Subject: M/39/22/DOC Briarfield

Please find enclosed a further response from our consultant in respect to surface water drainage.

Surface Water Chamber & Soakaway Constructional Details scale 1:25

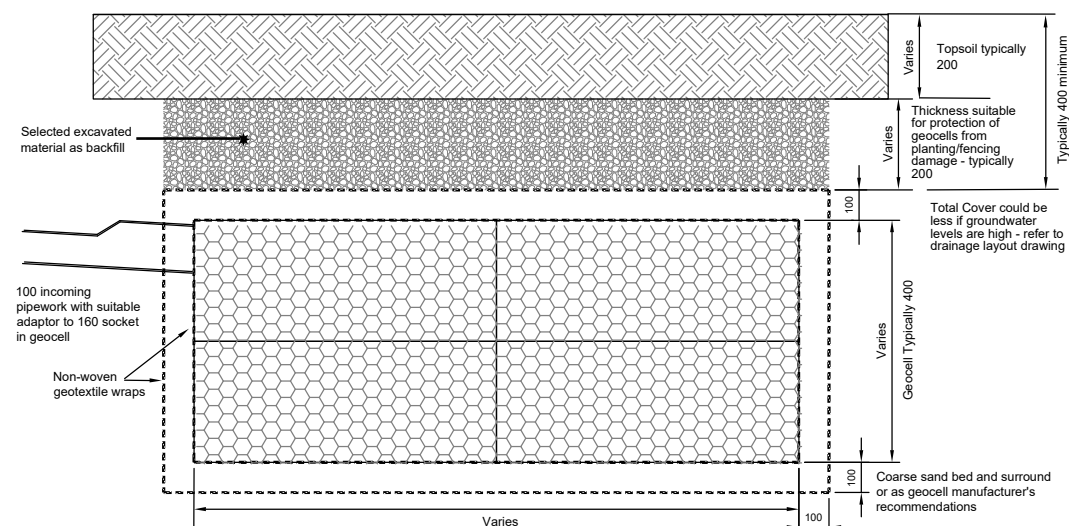
For a single house soakaway, we are happy to accept that this could be inspected by a camera from the proposed silt trap manhole, and as such, do not require a dedicated inspection manhole or cover.

Access for inspection is recommended in Section 13.12.1 of C753, (P286), this is not something we would expect on designs for relatively small developments (i.e. single dwellings or small extensions) providing upstream sediment traps are included to reduce the chance of the soakaway silting up, and access for inspection with a camera is possible.

Item 1) There is the manufacturer specification for the geocell included within the 'Key Detail' in the Layout Drawing including the unit size. How much more detail is required?

Item 5) This design, in common with many designs, has the invert level of the incoming pipe not marrying up with the molded socket on the geocell. In these instances, the builder generally cuts an access hole in the geocell and pokes the pipe through, taking due consideration of the sealing of the geotextile membrane. The Constructional Drawing will be changed to reflect this and reference to an adaptor will be removed.

We would prefer if this can be included on the section drawing (to reduce the risk of a contractor purchasing the wrong crates), however, we are willing to accept this as the details is provided.

No additional comments, thank you for confirming how the system will be sealed and for removing the adaptor.

Detailed
Drainage
Layout
Scale 1:200

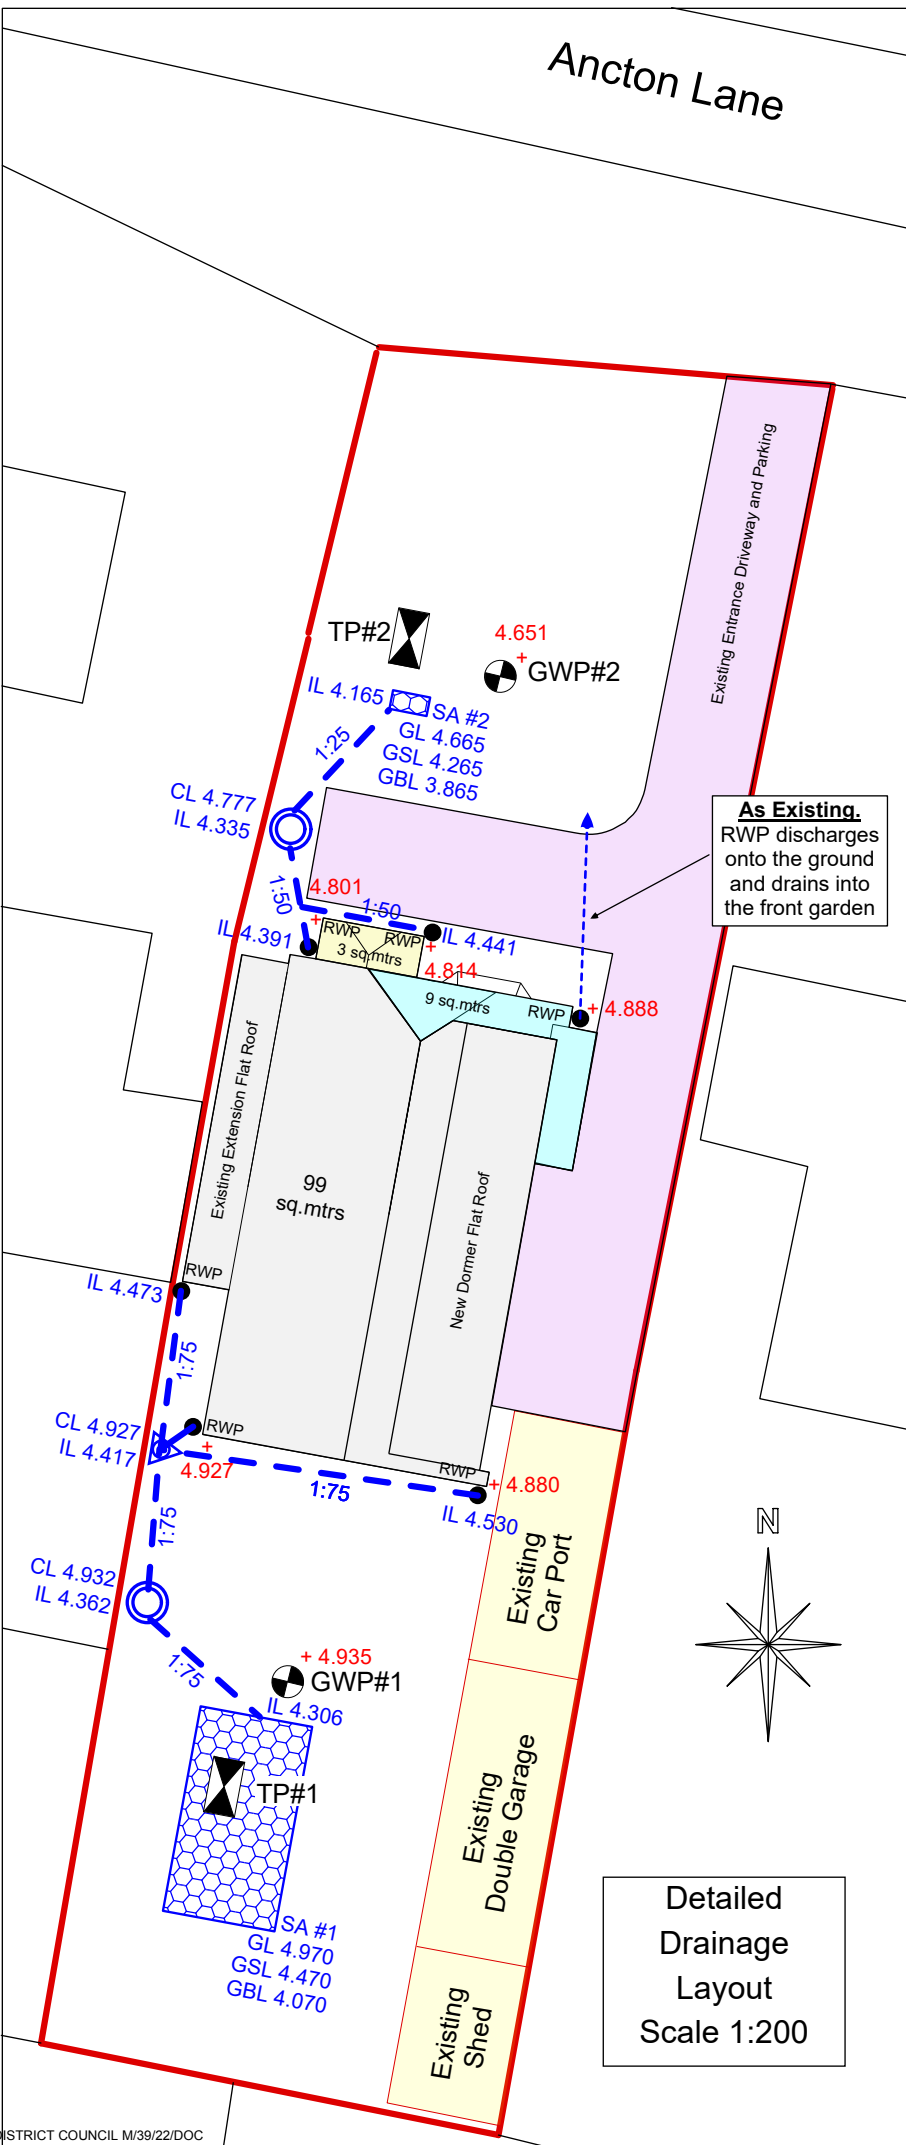
This is something we do require on this occasion and is needed because we sometimes spot check calculations to ensure rates have been calculated correctly.

Item 7) the current Finished Floor Level will be included on the Layout Drawing typically here 180mm above outside ground levels and 110mm above the ground level at the location of the soakaway structure.

In this specific case if this data has not been recorded and cannot be provided, we are willing to accept the results based on your drawing. This decision is informed by the fact the rates closely match with other results in the area, you are making a betterment, and your statement.

Thank you for confirming.
